CM/71/21/PL

The Arundel Gardener and Maidenhead Aquatics Crookthorn Lane Climping BN17 5SN

Retention of timber cladding to side (west) and rear (south) of mail building, lychgate to west of main building, timber cladding to generator housing & block paving and concrete slabs/ replacement concrete slabs (resubmission following CM/38/21/PL). This application may affect the setting of a listed building & is in CIL Zone 5 (Zero Rated) as other development

**As-Existing Elevations
with Proposals**

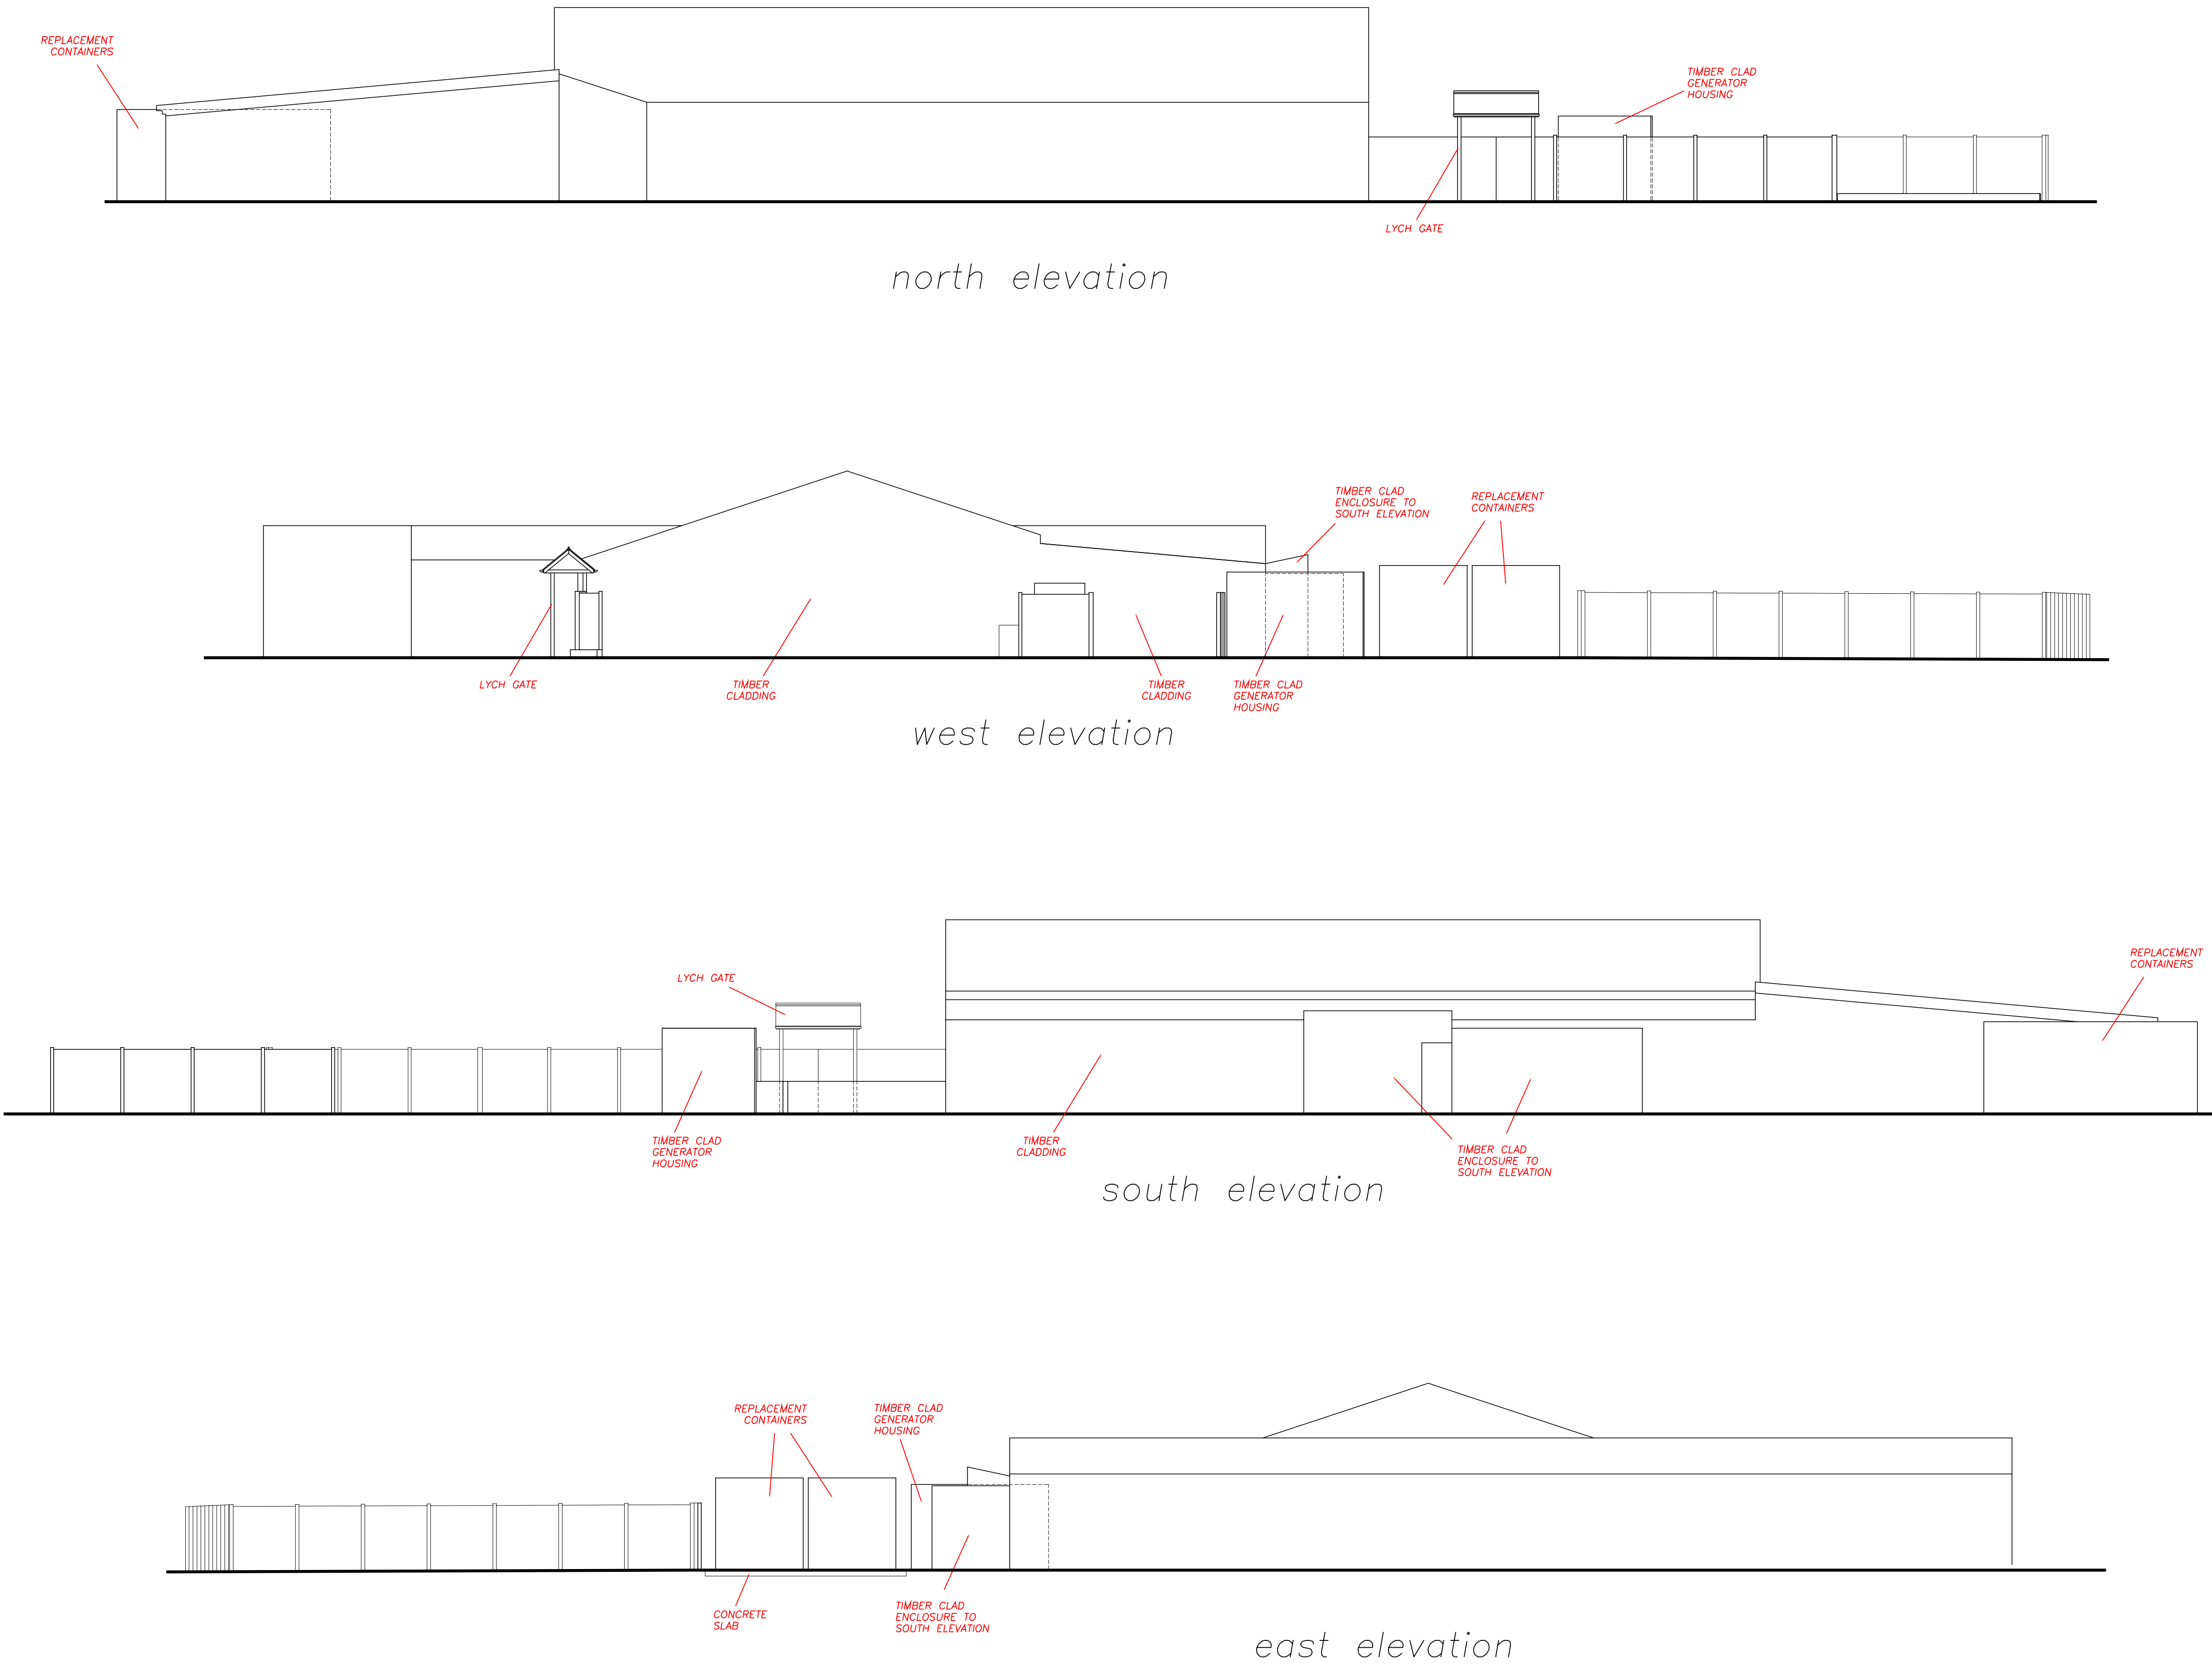
The plans indicate that it is only the western and southern elevations which are to be clad in the timber. This timber cladding appears to be an improvement upon the previous metal sheeting and is therefore acceptable. Likewise, the lychgate to west of main building, timber cladding to generator housing, are acceptable.
